From: Sue Howell
Sent: 12 July 2018 18:04
To: Planning.Responses
Cc: Juan Baeza
Subject: RE: Planning Consultation on: A/51/18/PL

Comments from Greenspace

Site Address: Pound Place Roundstone Lane Angmering BN16
4AL

Description of Works: Demolition of existing dwelling & erection of a 71
bedroom care home (C2 Residential Institution)
with car park, landscaped gardens & access from
Roundstone Lane. This application is a Departure
from the Development Plan.

**TREE PROTECTION PLAN**

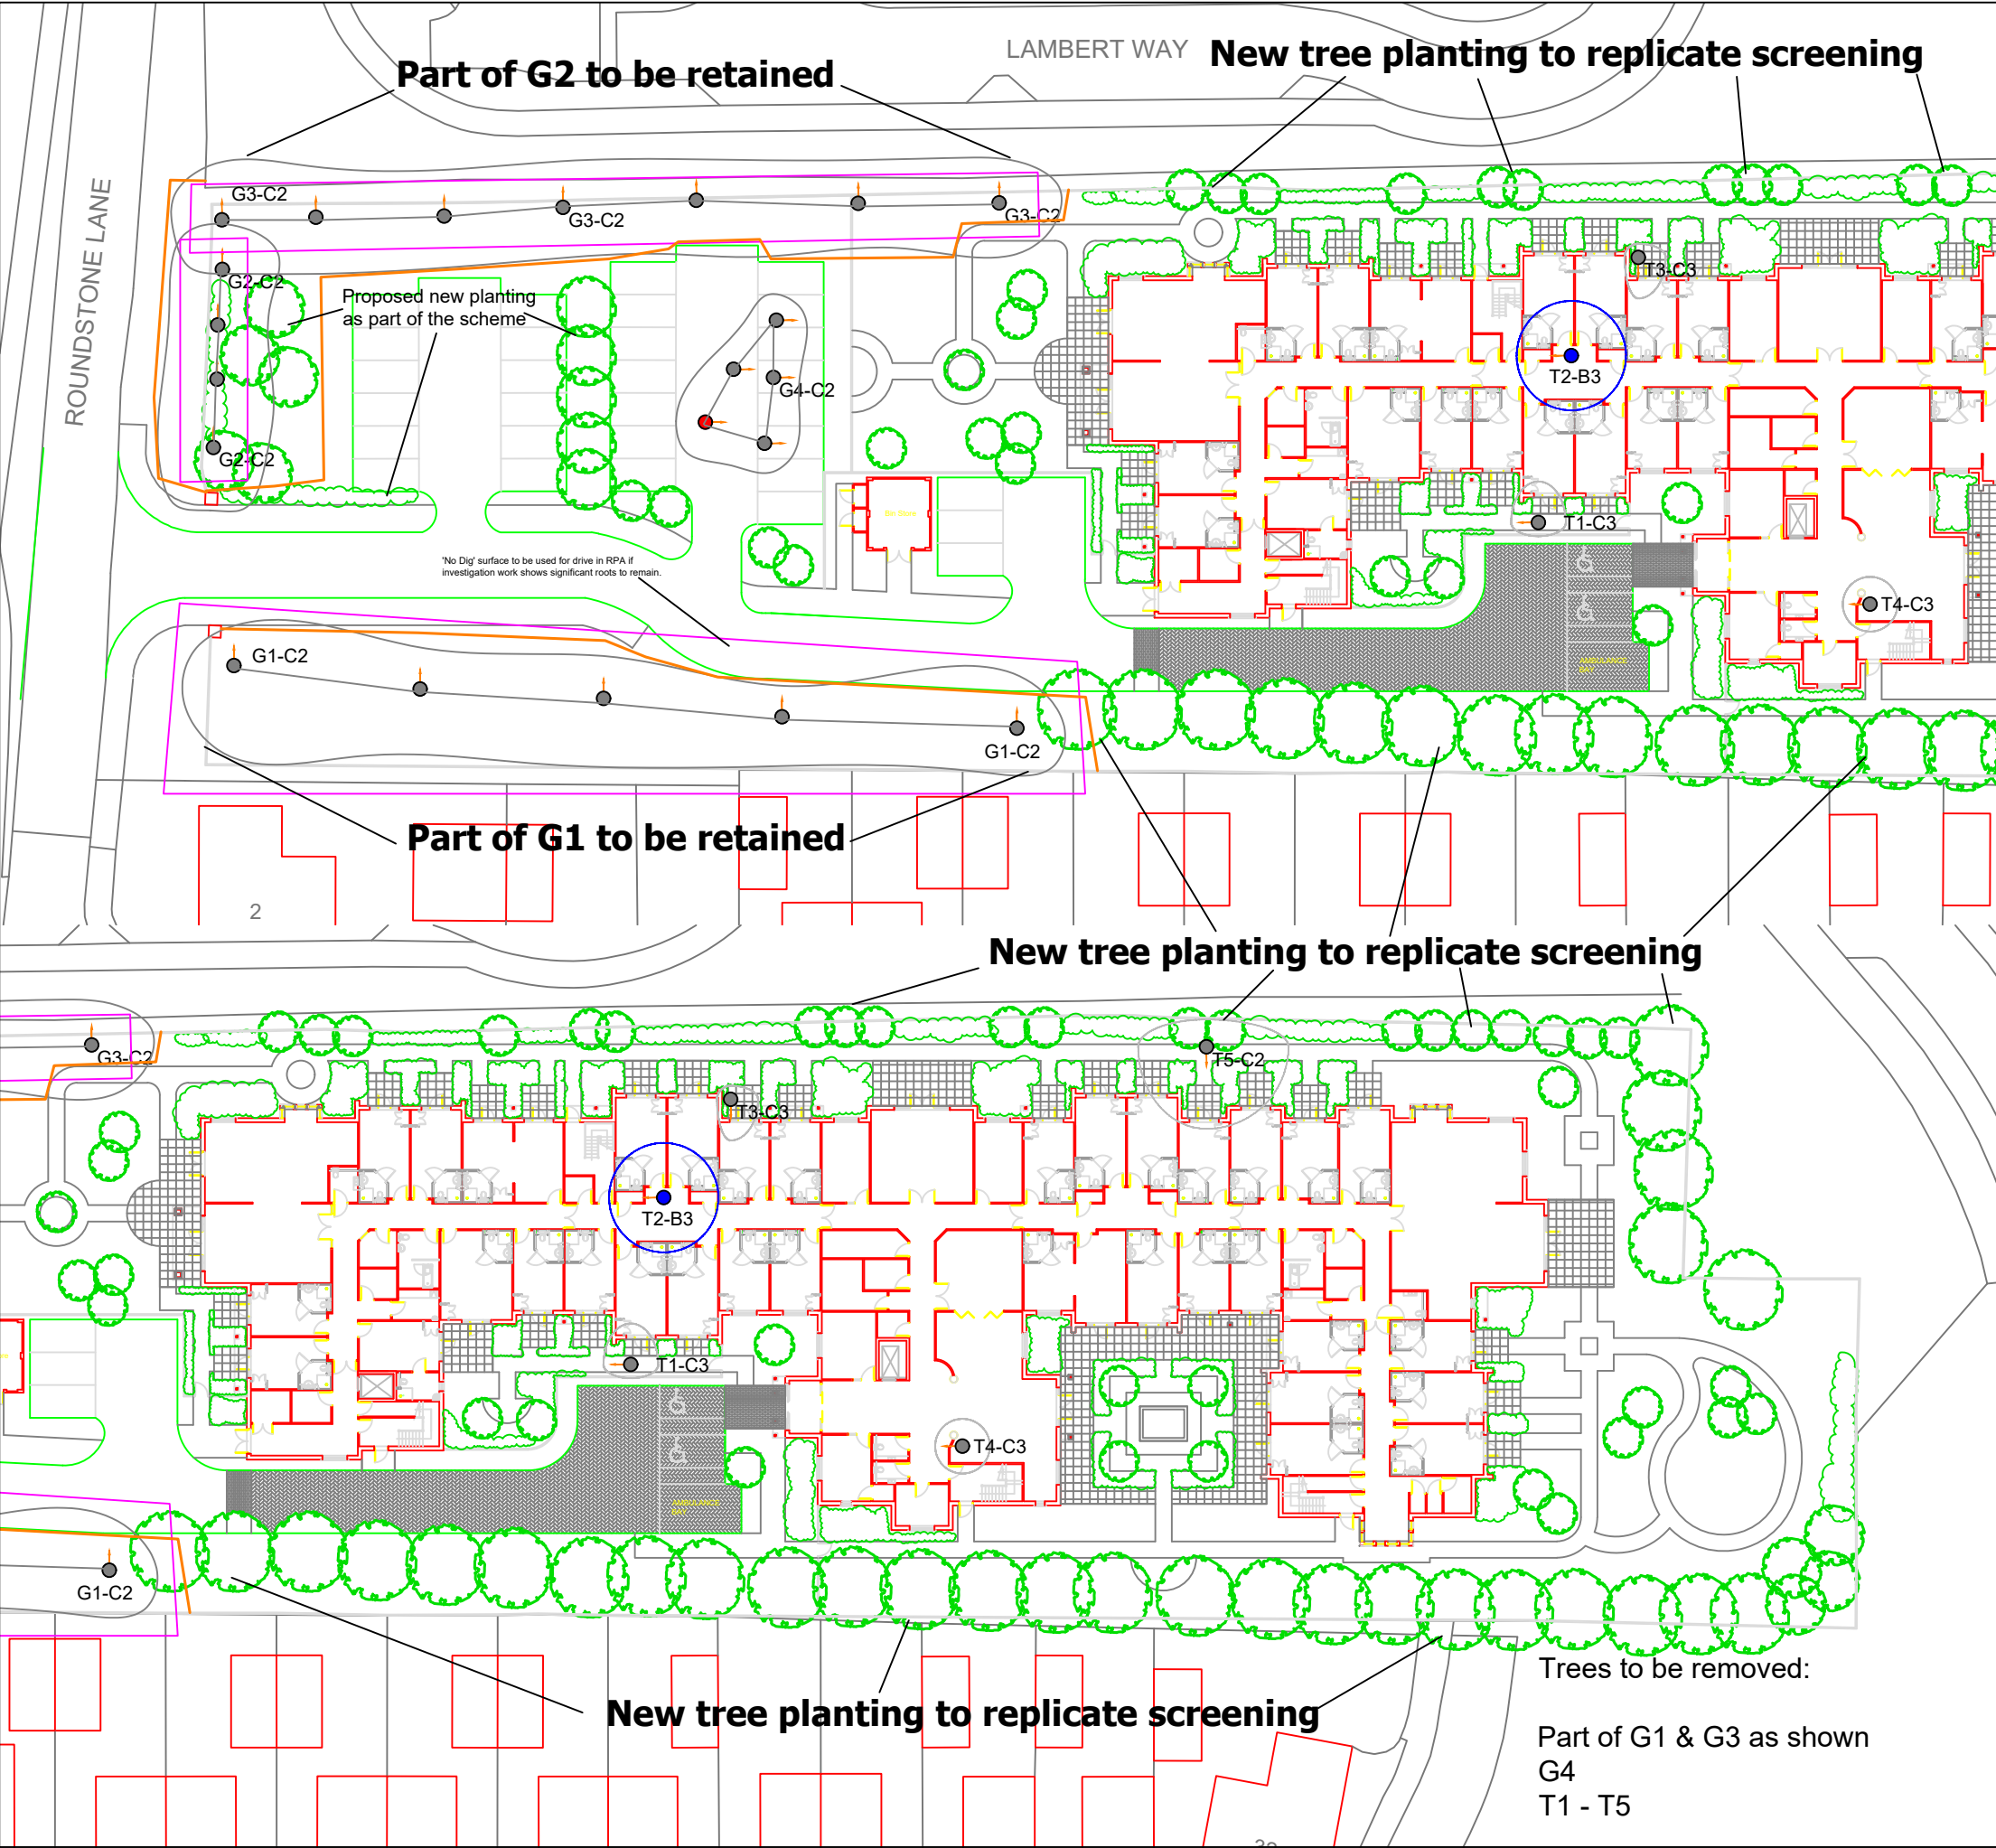
The proposed site is screened extensively to all sides and of note are the TPO's which have been applied to protect much of this established tree cover. Significant tree and vegetation removal has been indicated to facilitate the proposals within the indicative plans submitted. If tree removal were to be considered to facilitate this development in relation to its setting and the adjoining dwellings then a landscape scheme will need to be detailed, be appropriate for setting, provide mitigation where appropriate, provide screening to the new building, but will also provide a scheme which will enhance and provide a garden setting for the use of the proposed residents, their visitors and care home staff. Any scheme must take into consideration the needs of the development along with the wider viewpoints. Consideration should be given to species choice for these locations. The indicative drawings indicate some landscape consideration, this would need to be detailed with consideration for creating outdoor open space for the users as well as the location of these proposals within an established garden setting. The need for the establishment of quality, safe and stimulating outdoor space to be provided should be key to the design and executed to a high standard.

A comprehensive tree survey in accordance with BS5738 would need to be undertaken and tree protection fencing identified with the tree protection plan to be identified and applied to any permission.

Any considered tree removal from this site should be agreed with Arun District Councils Tree Officer. Root protection Areas (RPA) should extend into the development site and to those in neighbouring land. Before construction, a tree protection scheme must be in place for any retained trees including trees whose root protection areas fall within the construction zone from neighbouring land. This should be in accordance with BS 5837:2012 'Trees in relation to construction' Any removed trees should be mitigated for allowing for inclusion of native species for biodiversity purposes and fitting to this setting.
